**Reference: 25/01768/HYBRID**

**Location: Land At Graven Hill London Road Bicester**

### **Holding objection**

## **Stage 2 Phase 1 detailed application – Holding Objection**

Amendments	
Project	GRAVEN HILL
Title	STAGE 2 ACCESS PARAMETER PLAN

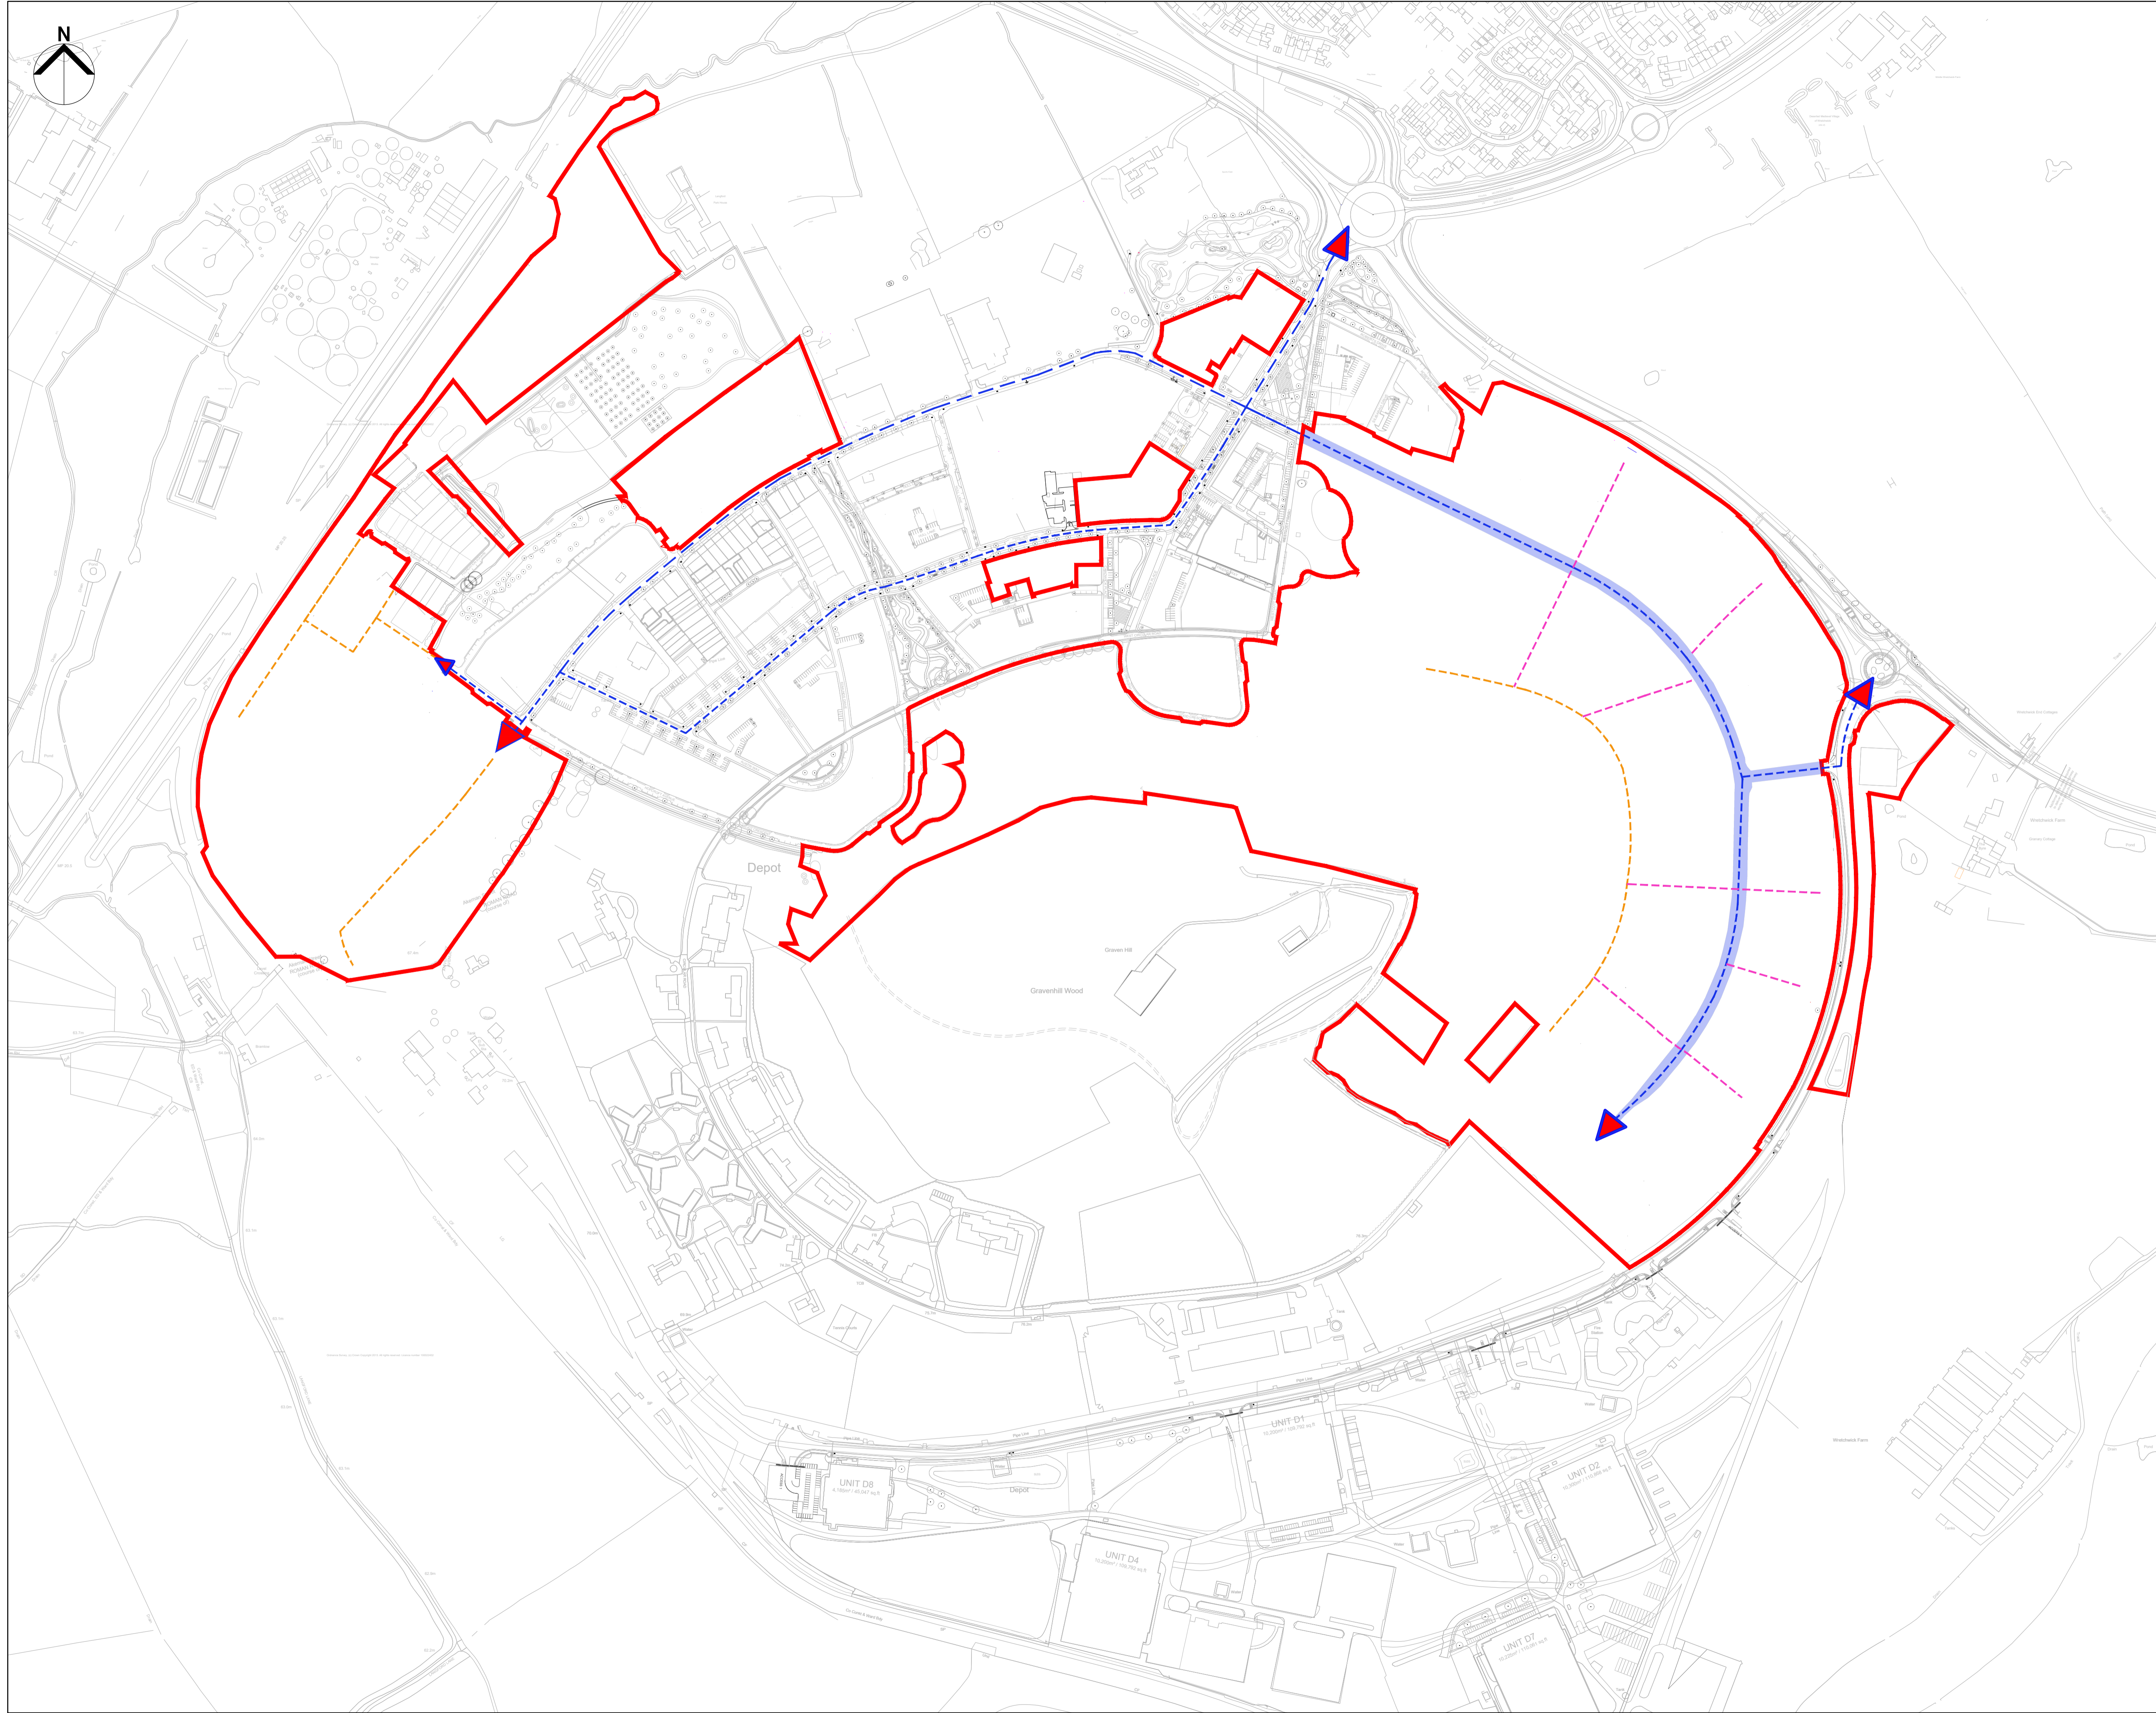
I have concerns that the outline parameter plans provided at outline stage for the development are far too detailed, as all matters for the outline Application are reserved. As such, at this stage it would be more appropriate for all parameter plans to be high level general plans without definitive details. It should not be considered that the acceptance of any illustrative documents indicates acceptance of the intricate detailed elements within – I have not reviewed them in detail for this reason. I ask that the submitted parameter plans are removed, and replaced with general high level plans omitting detailed design.
